PLANNING CONSULTATION RESPONSE

Application No	
Proposal	
Address	113 Hoyland Road Hoyland
Date of Consultation Reply	16/7/26
Consultee	Daniel Moore

Consultation Assessment and Justification

**Appendix 5:
Tree Constraints Plan**

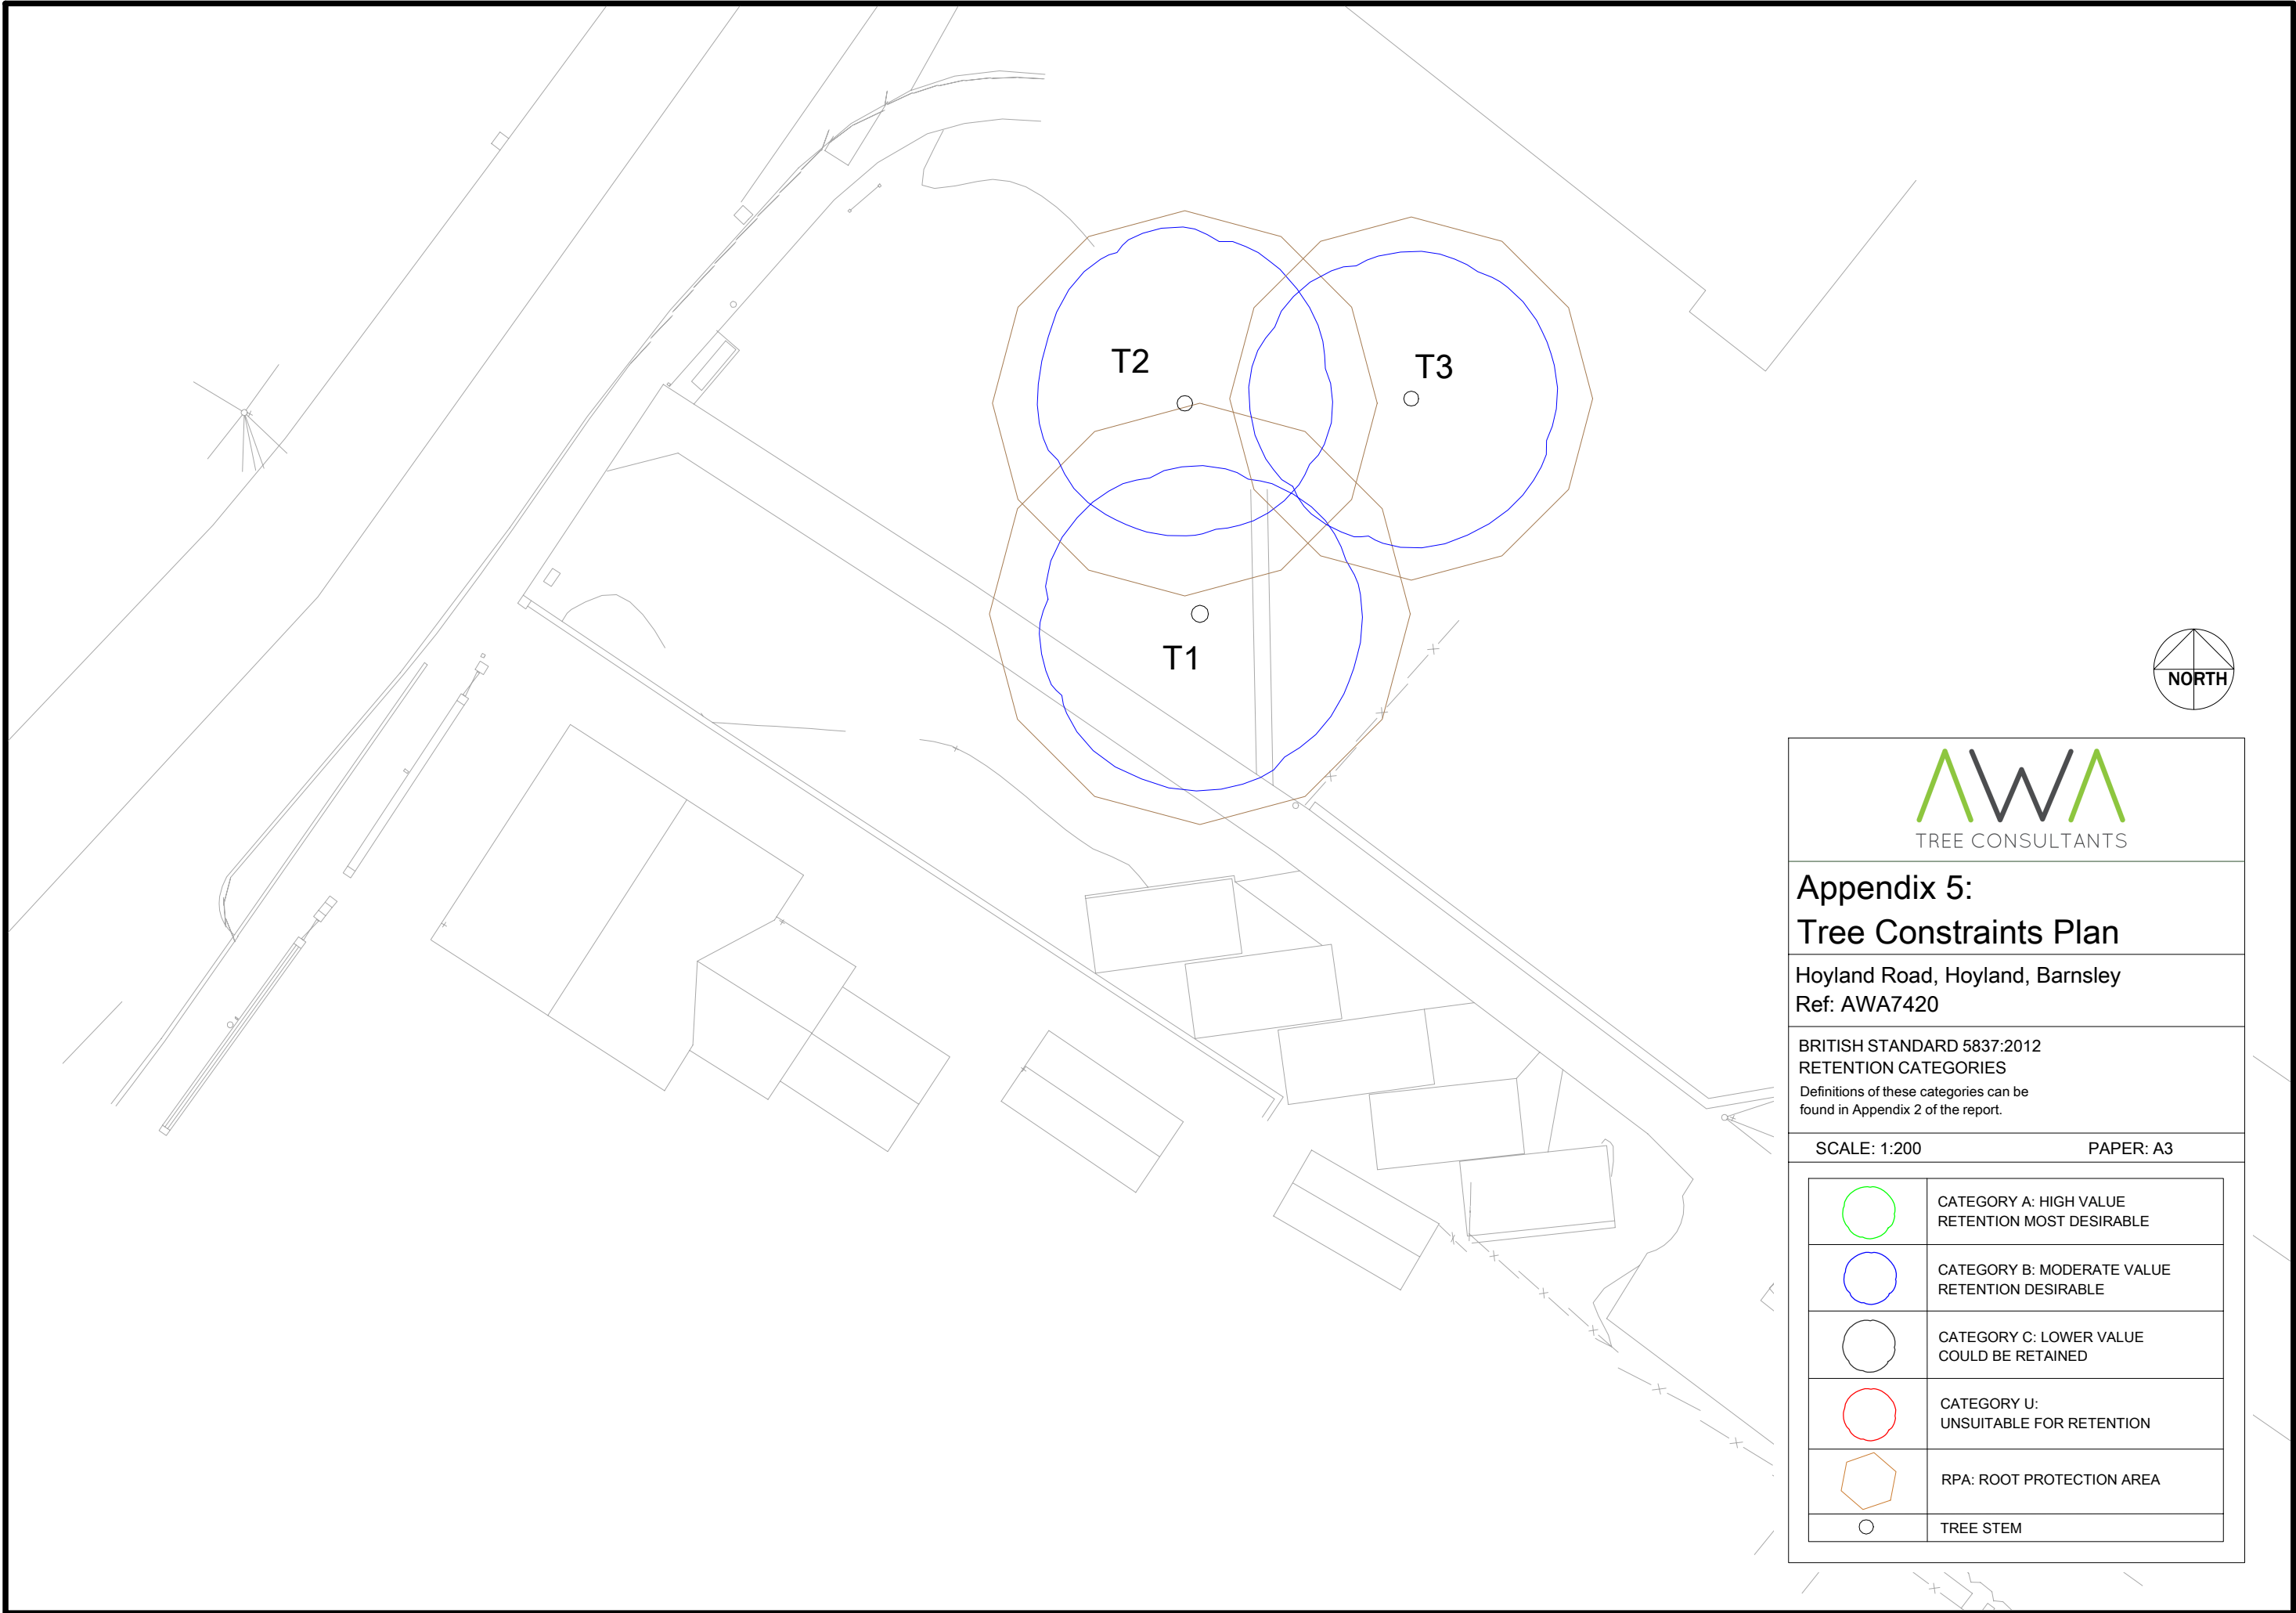
The CAVAT value of the tree closest to the proposed development is £116,318, demonstrating its significant public amenity value, the other two trees in the area have a similar value as well. The nearest tree has a calculated Root Protection Area radius of 7.2 metres which extends substantially into the proposed development site. In addition, the tree's canopy currently extends to the site boundary and will directly interact with the proposed development.

The tree survey in the application indicates the trees only have a life expectancy of 20-40 years which I disagree with as they are not fully mature yet and the species can in the right conditions live for a couple of hundred years.

Project	Detached Dwelling	
Client	Mr Shane O'Keefe	
Title	Site Layout	
Address	Adj. 113 Hoyland Road, Hoyland Common, Barnsley, S74 0AP	
Drawn By	GGG	
Scale	1:200 @ A3	Date Apr 26
Drawing No	531-01	Rev

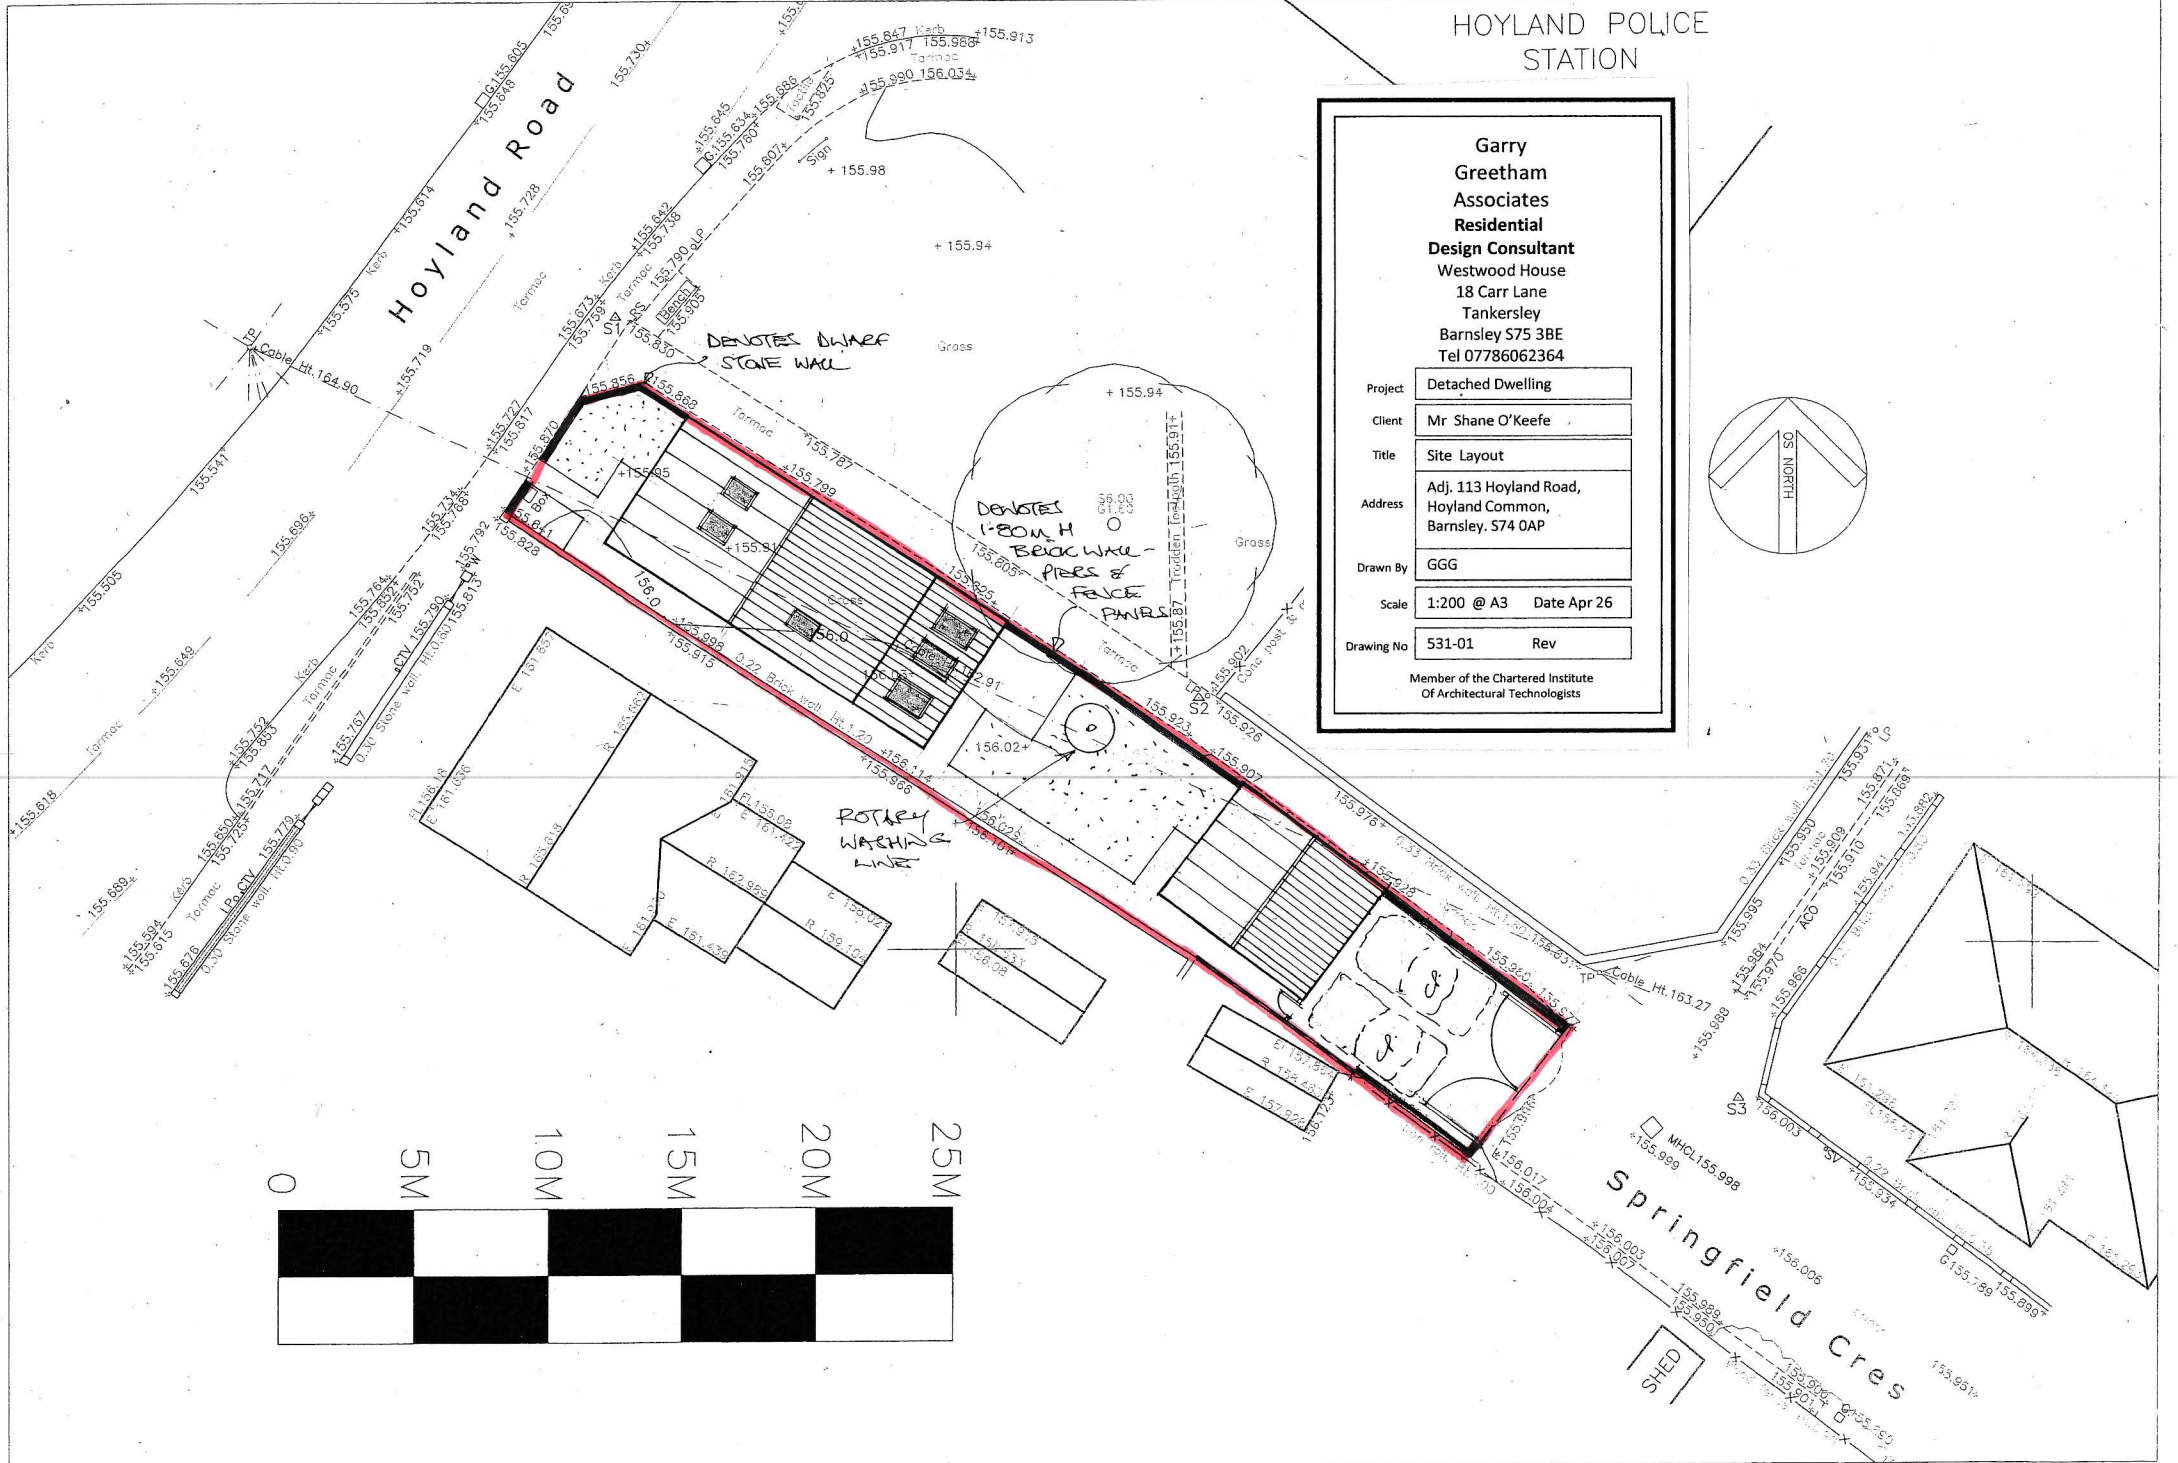
The submitted proposals would place the new building in close proximity to the tree, resulting in an immediate requirement for pruning to facilitate scaffold erection and construction activities. Furthermore, due to the limited separation distance between the tree and the proposed building, the tree is likely to generate ongoing management pressures through continued crown growth adjacent to the structure.

It is foreseeable that this relationship would lead to repeated requests for pruning works throughout the life of the development and may ultimately result in pressure to remove the tree altogether. Such outcomes would be detrimental to a tree of significant amenity value and would conflict with the long-term retention objectives of good arboricultural practice.

Given the encroachment into the calculated Root Protection Area and the likely future pressure for cyclical pruning or removal, serious concerns are raised regarding the compatibility of the proposed development with the successful long-term retention of the tree.
